Date: 13-Jul-2026
Our Ref: 2026/91286

**Application for Approval of Details Reserved by Condition
Town and Country Planning Act 1990
Planning (Listed Buildings and Conservation Areas) Act 1990**

**Discharge of details reserved by conditions 4 (dilapidation survey), 5 (Phase I Desk Study Report), 6 (Phase II Intrusive Site Investigation Report), 7 (Remediation Strategy), 8 (accordance with the Remediation Strategy), 9 (Verification Report), 10 (ecological enhancement measures), 11 (waste collection) and 14 (materials) on previous permission 2025/90583 for erection of rear dormers, raising of roof height and alterations to workshop to form dwelling
2, Elm Street, Skelmanthorpe, Huddersfield, HD8 9BH
Application Number: 2026/91286**

Drawing Title:
Proposed Location & Site Plan

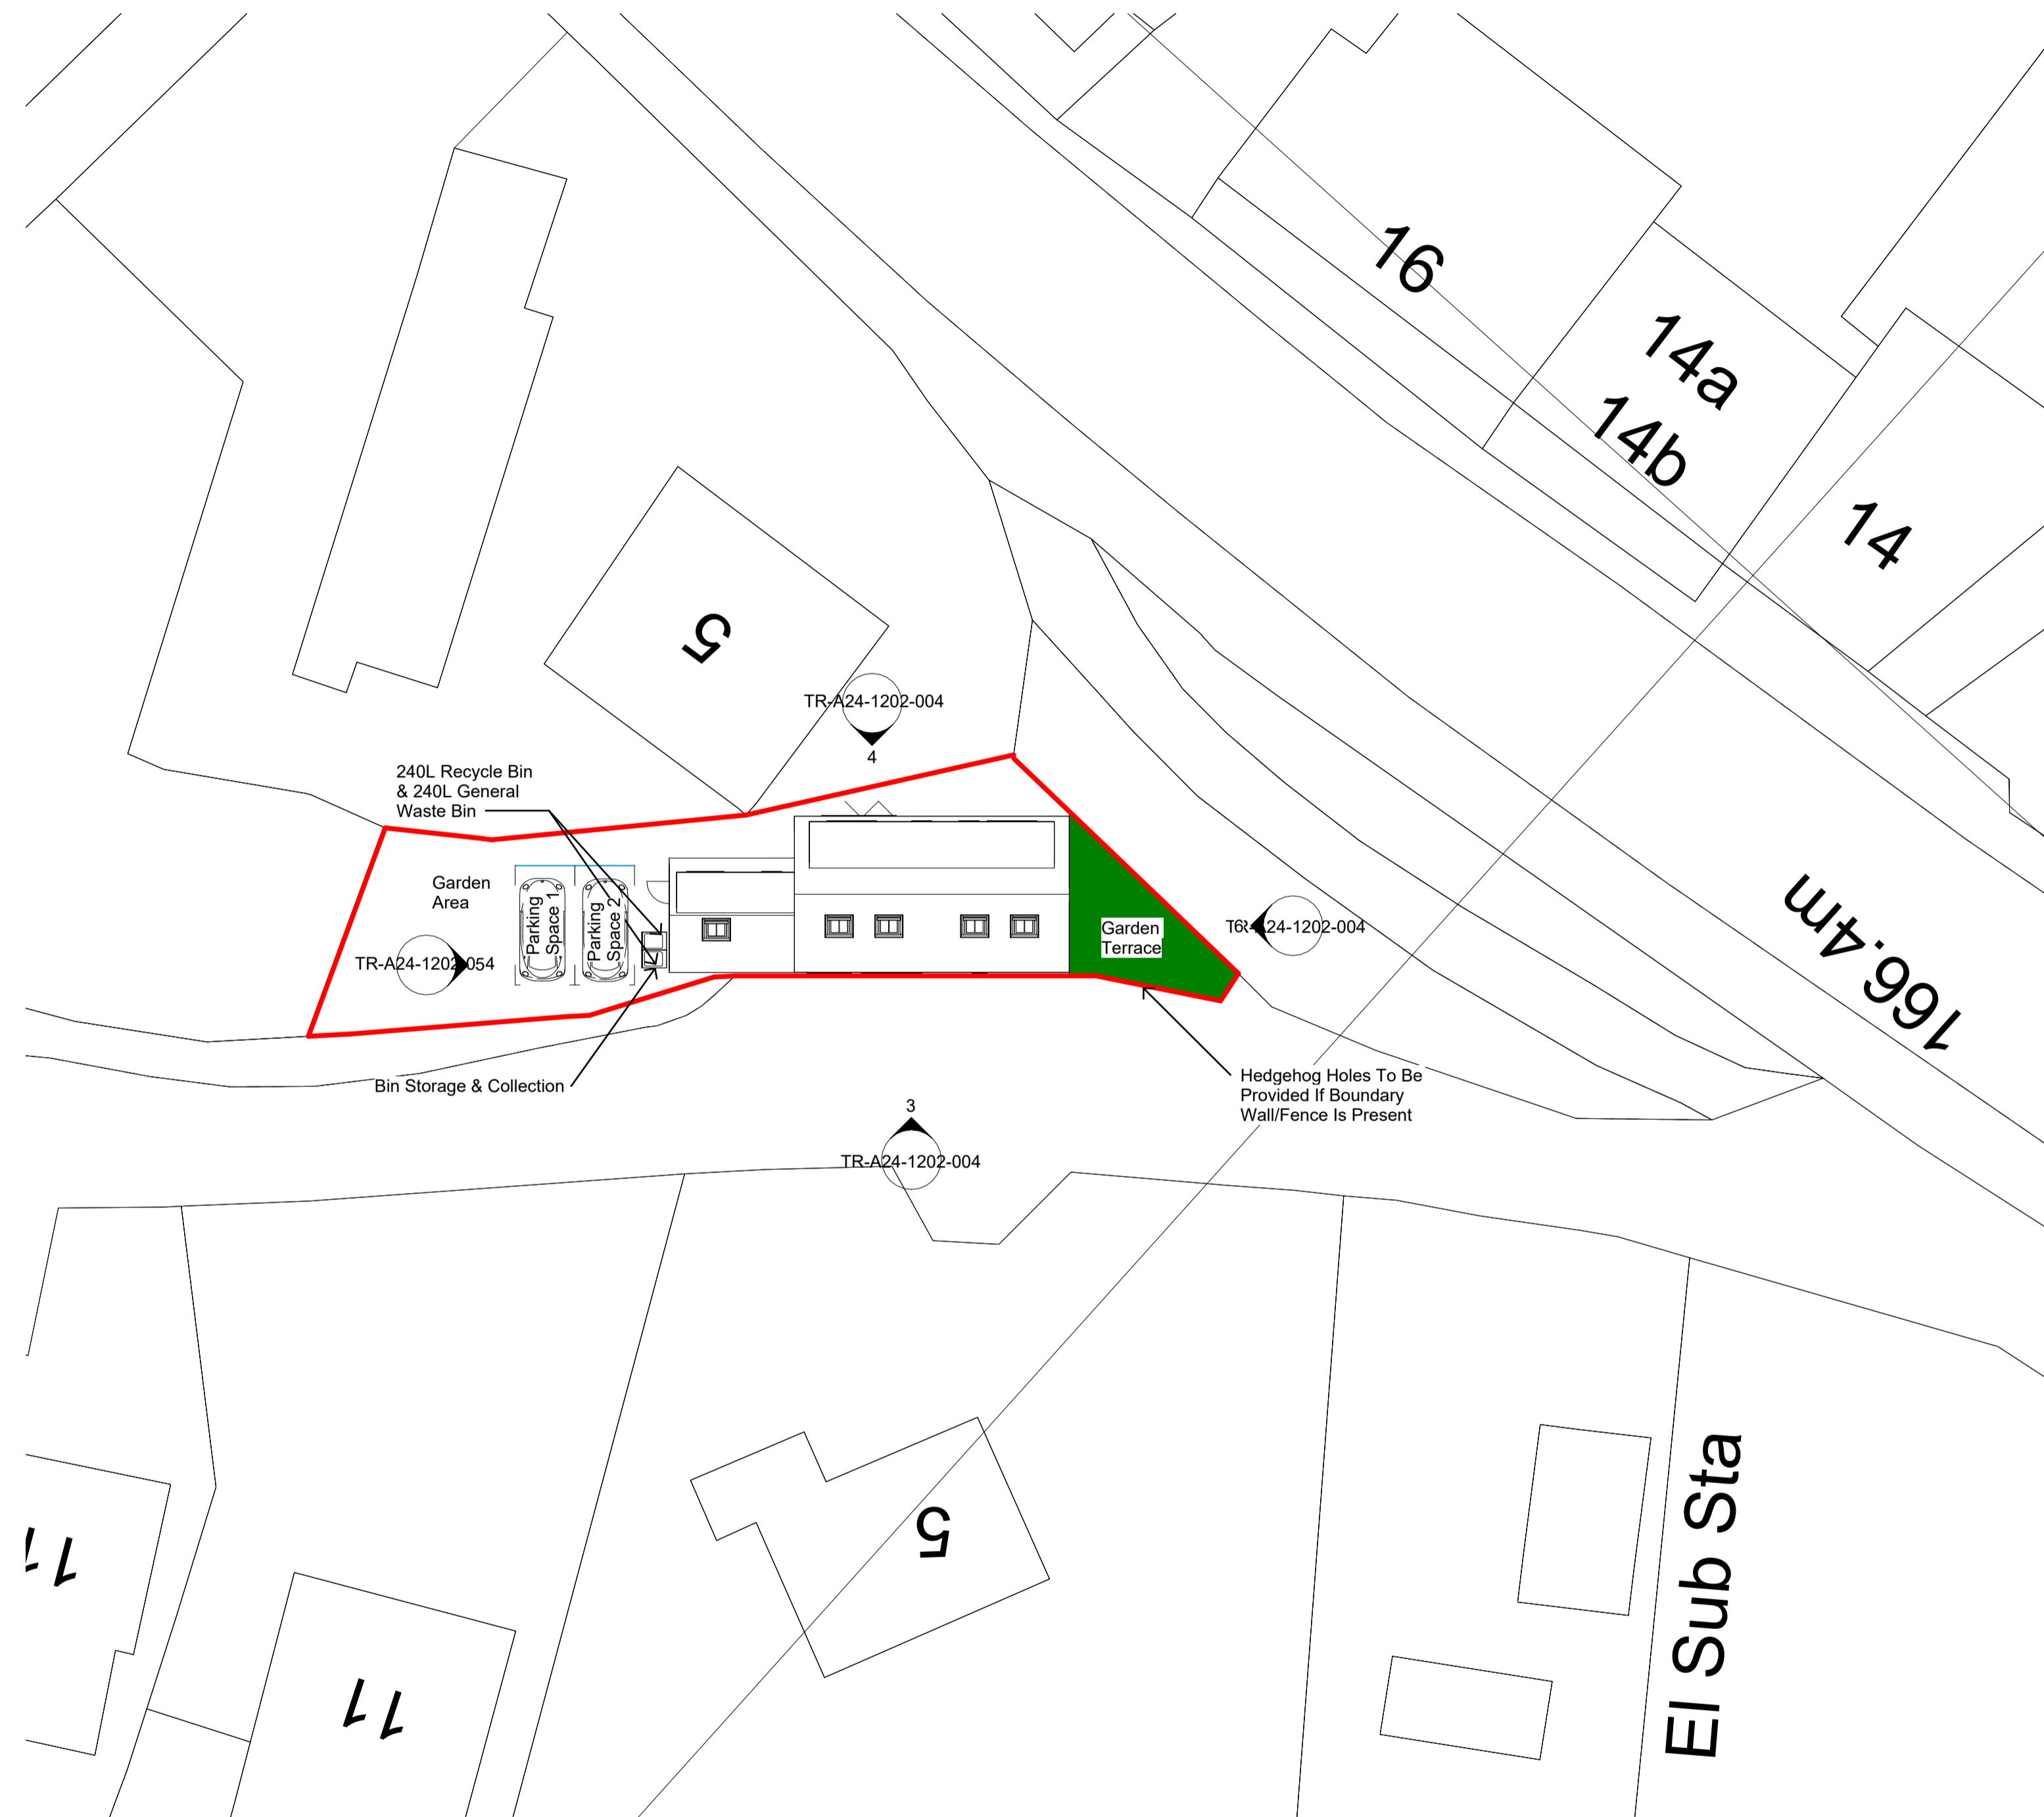
Officers have consulted with KC Ecology on the application; no details have been provided in support of condition 10. The boundary treatments on site have not been confirmed nor the location of a swift box. Therefore, condition 10 is not satisfied and cannot be discharged.

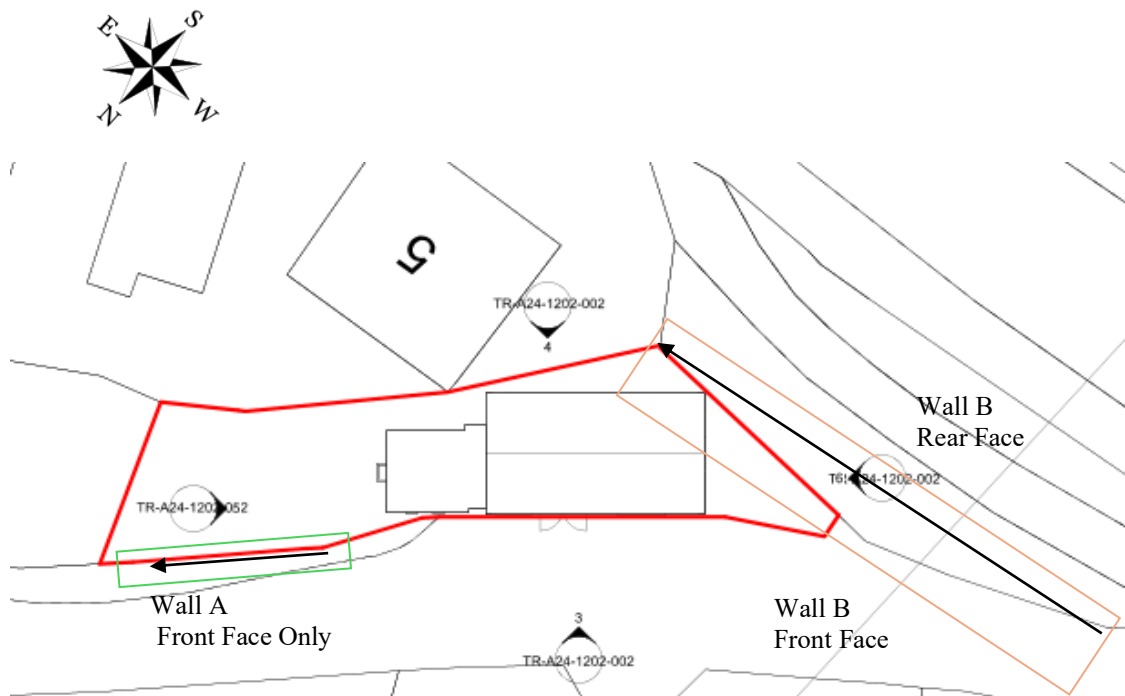
The details provided have been reviewed by KC Highway structures and it is considered that the details provided satisfy the first part of the condition pertaining the existing wall structures.

This condition cannot be fully discharged at this time as a further structural dilapidation survey of the retaining wall is also required following the completion of the works and any defects arising in the wall due to the works associated with the proposed development

shall be made good to the satisfaction of the Council's Highway Structures team, at the developer's expense.
